**Byers Gill Solar – EN010139**

**Section 51 advice regarding draft application documents submitted by JBM Solar**

Drawing Title
LAND PLAN
KEY PLAN
REGULATION 5(2)(i)

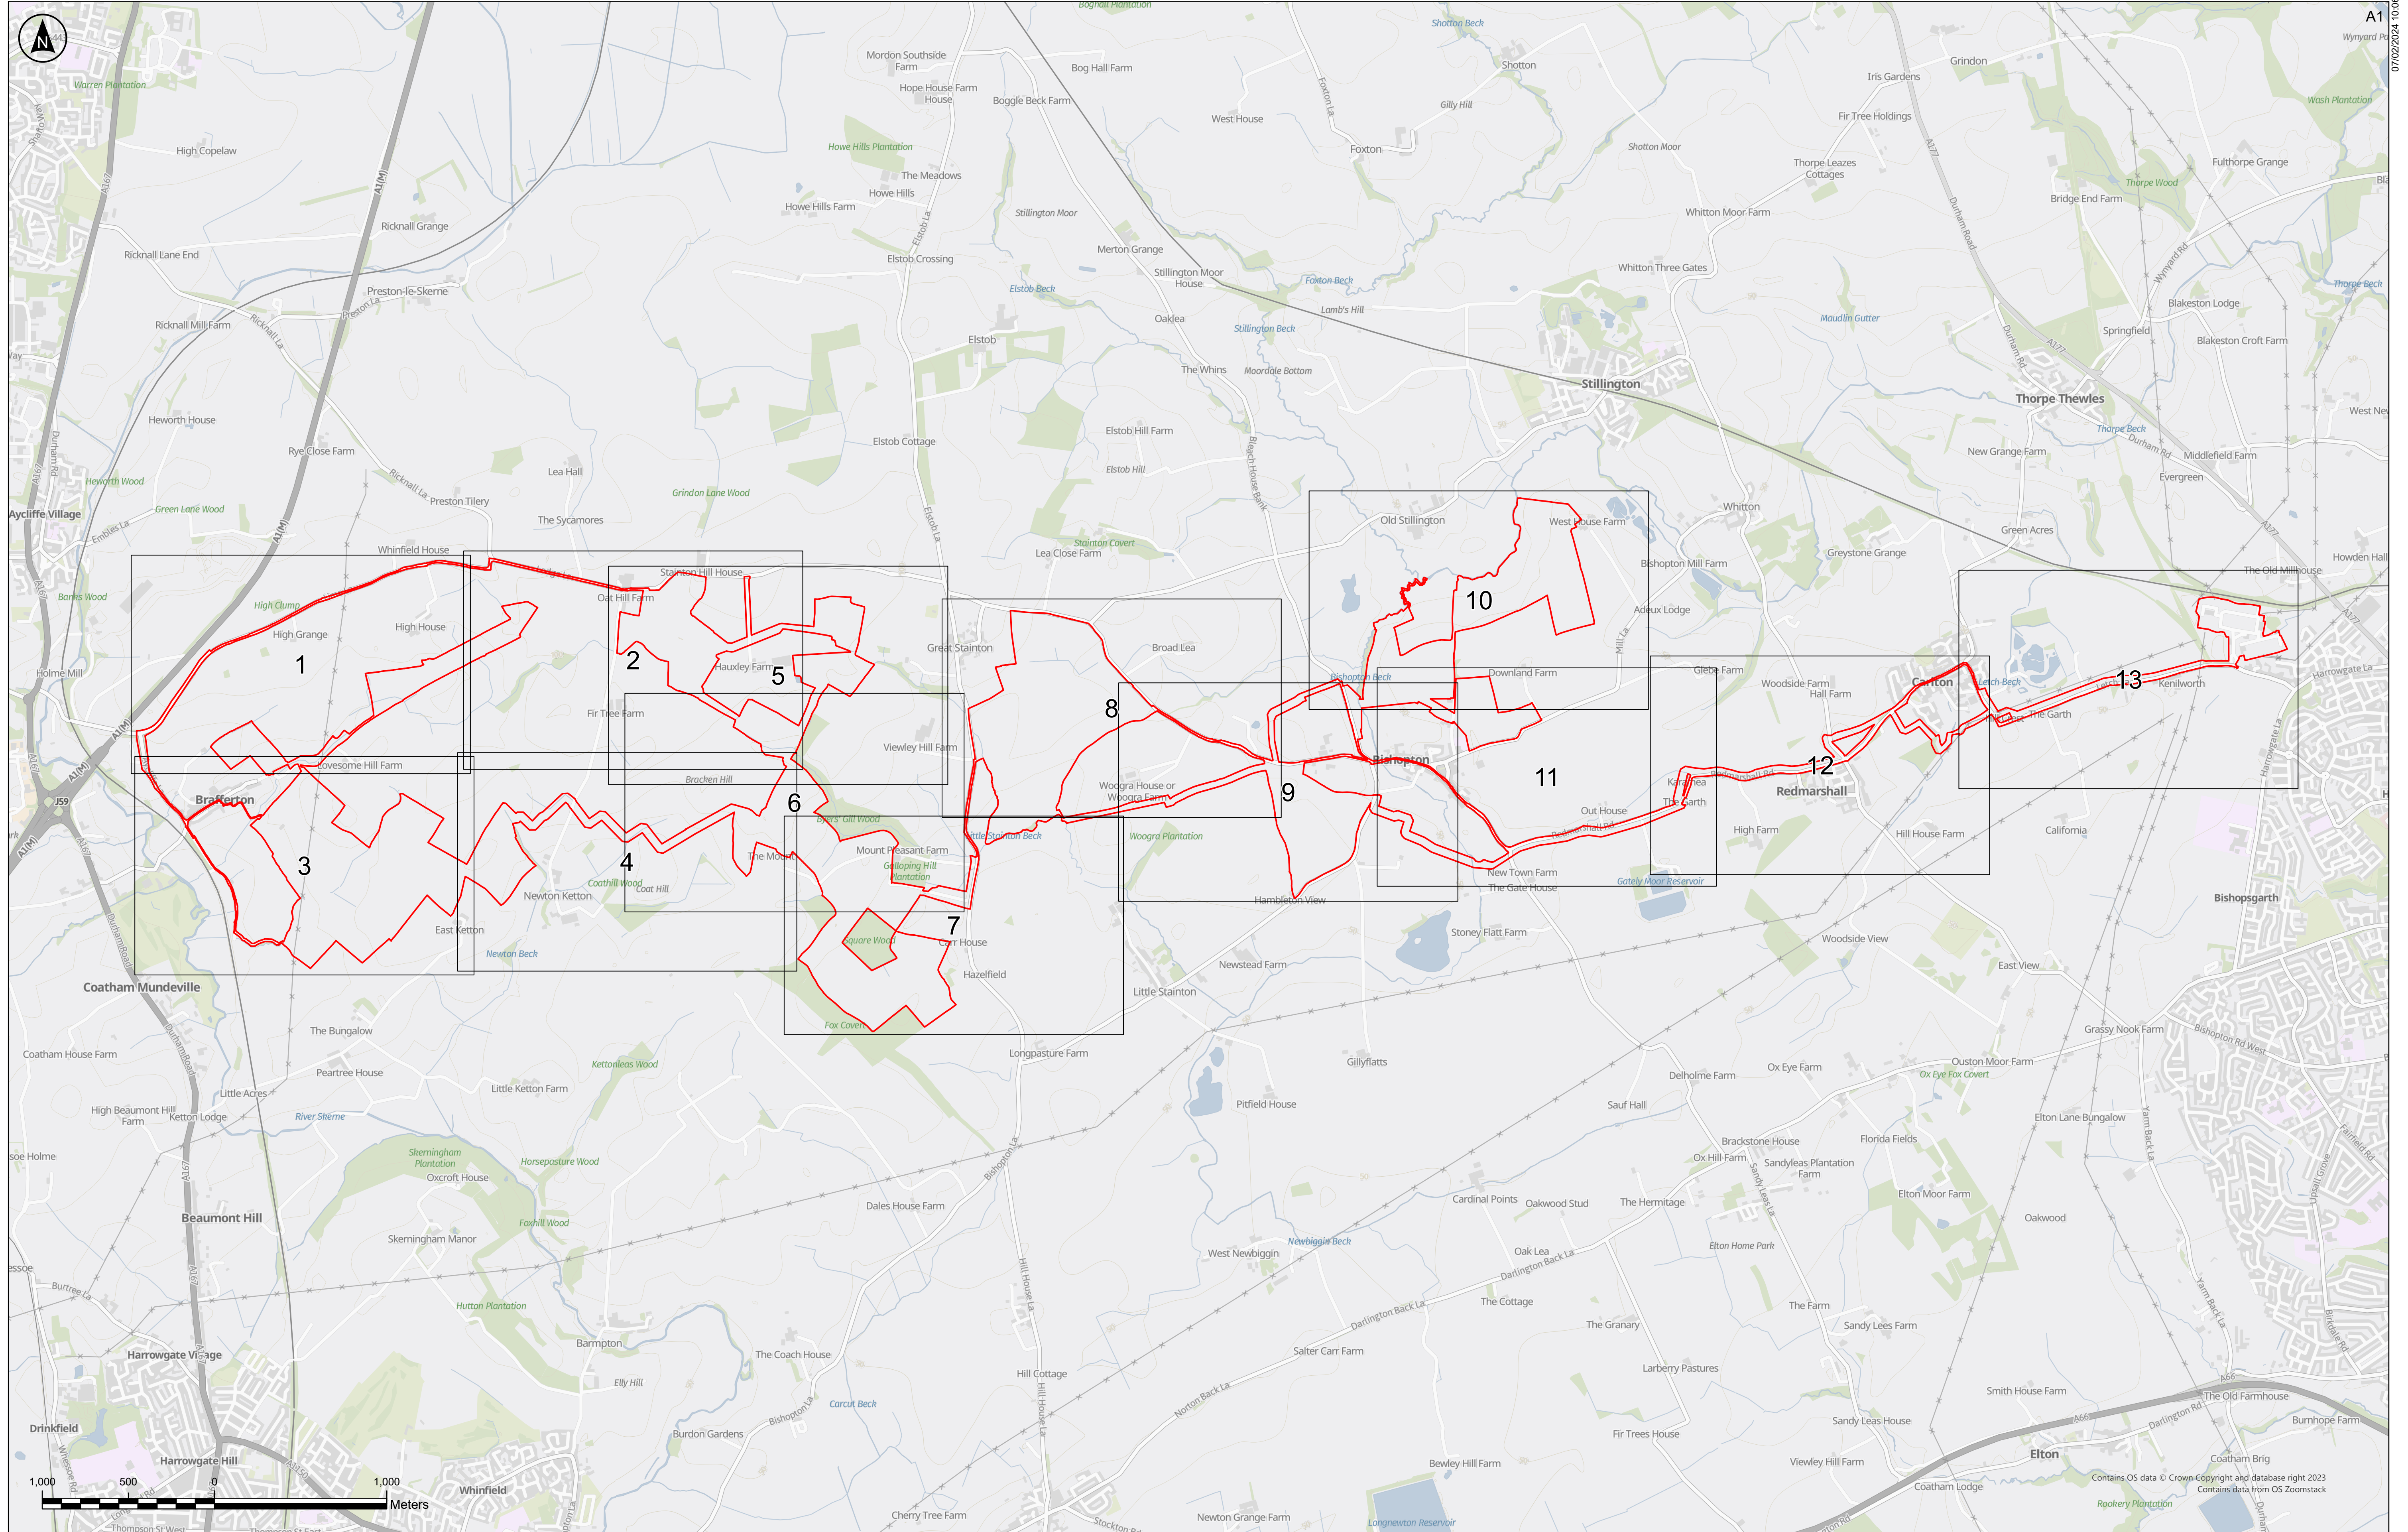
18.	<b>Key plan</b>	<p>The Applicant is reminded that The Infrastructure Planning (Applications: Prescribed Forms and Procedure) Regulations 2009 (APFP 2009) Regulation 5 (4) requires a plan comprising three or more sheets must be provided with a key plan showing the relationships between the different sheets. It is recognised that a key plan highlighting the current sheet is shown on each sheet and that there is also an overarching sheet provided. This does not appear to be consistent approach with that taken with the Works Plan.</p> <p>The Applicant may wish to reflect on its approach and consider if there is value to a consistent approach to plans in seeking to meet the requirements of Regulation 5 (4).</p>

19.	<b>Key plan and Sheets 1-13</b>	It is noticed that both the overall key plan and the associated individual sheets state their scale as being 1:2500 at A1. The Land Plan Sheets and the Key Plan are clearly at different scales, and this brings into question the scale of the Land Plan and compliance with The Infrastructure Planning (Applications: Prescribed Forms and Procedure) Regulations 2009 (APFP 2009) Regulation 5 (4A). It appears likely the Key Plan is incorrect in its quoted scale. The Inspectorate would like to remind the Applicant that such inaccuracies reduce confidence that any or all stated information is accurate.

Land Plan		
Ref No.	Plan ref	Comment/Question
		The Applicant may wish to check the scales of the sheets of the plan provided and ensure that the scale is correctly stated on each sheet.
20.	<b>General and Part 5 of the dDCO</b>	<p>It has been noticed that the draft Development Consent Order refers to all land within the order limits being within the scope of Compulsory Acquisition powers, but this is not what is shown in the Land Plan, which most of the land appears to have been shaded in conformity with the legend entry for land that is not subject to compulsory acquisition. This could cause confusion as this does not appear to be consistent.</p> <p>The Applicant may wish to review this point and ensure that there is consistency between different documents and clarify the position in relation to Compulsory Acquisition powers.</p>
